SPR EA1N and EA2 PROJECTS

DEADLINE 2 - COMMENTS ON STATEMENT OF COMMON GROUND WITH ESC/SCC

Interested Party: SASES

Friday Street Mitigation Scheme
(A12 / A1094 Friday Street)
Proposed Signage Layout -
Preliminary Design

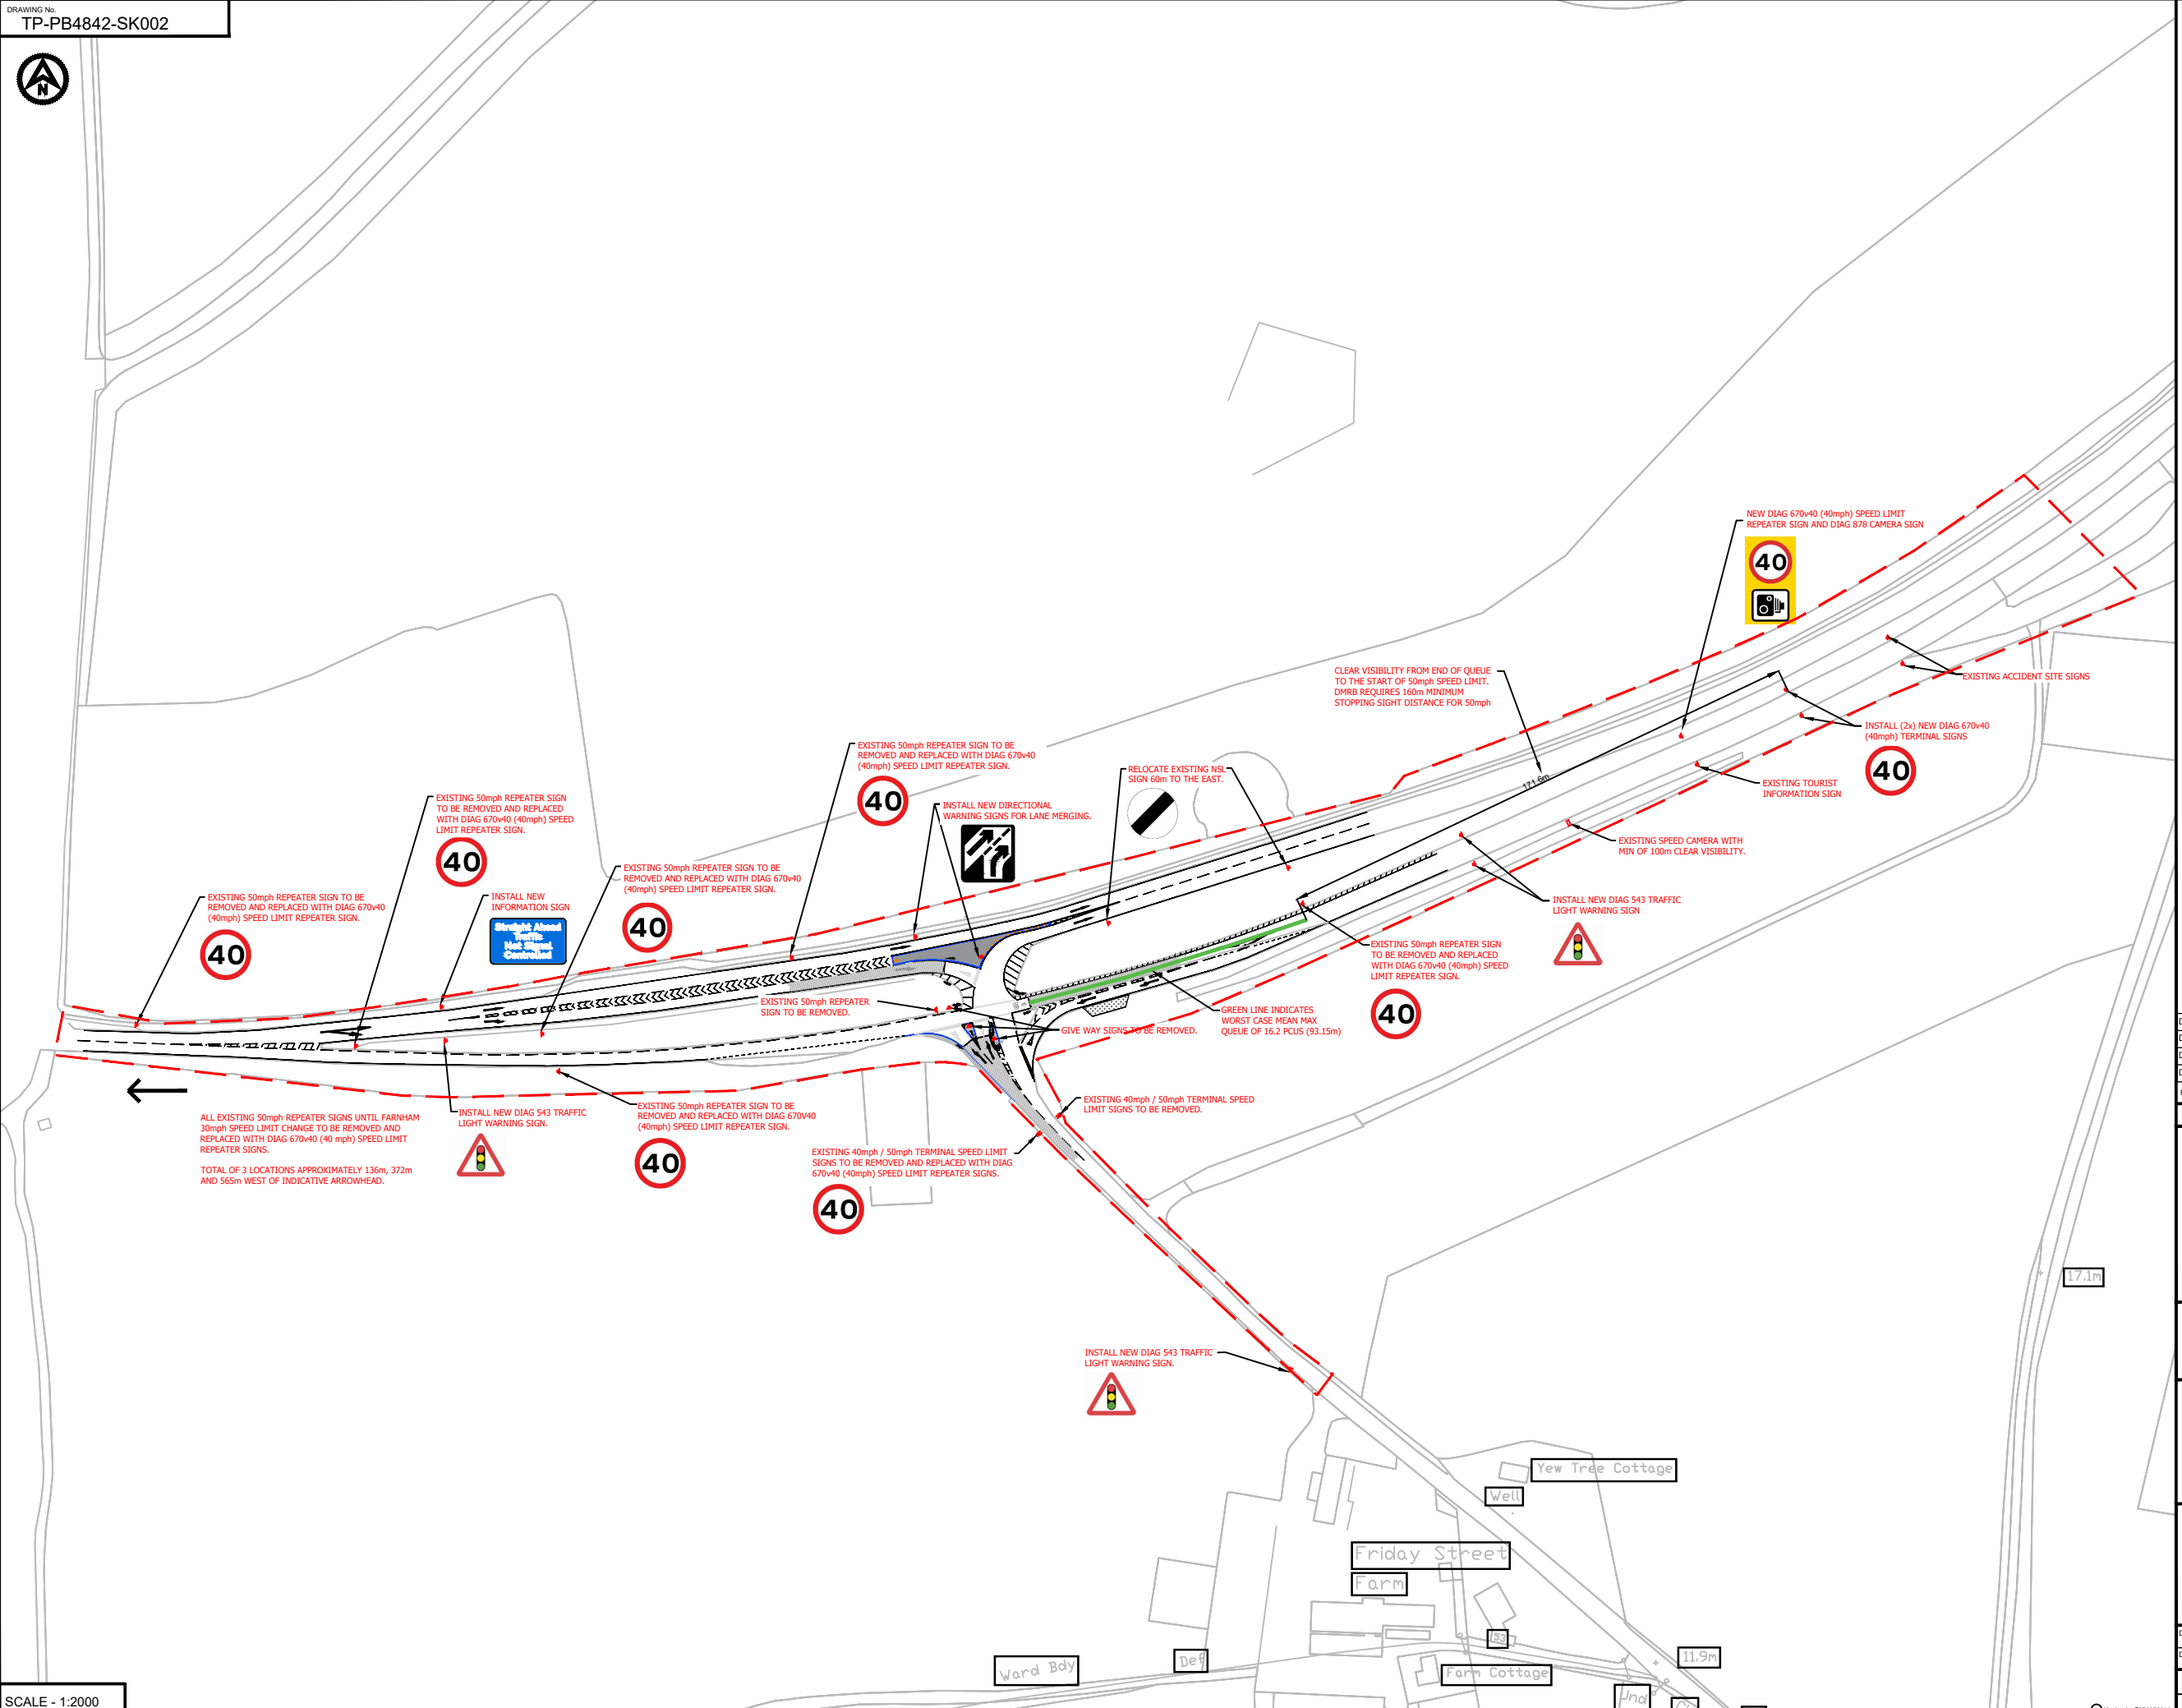
| LA-10.25 Mitigation | The mitigation in relation to Friday Street Junction set out within the assessments and the proposals for a traffic light system coupled with speed limit reduction are acceptable and sufficient subject to | SASES views with deep concern the introduction of traffic lights at the Friday Street junction and the potential to disrupt severely traffic flow over a wide area. |
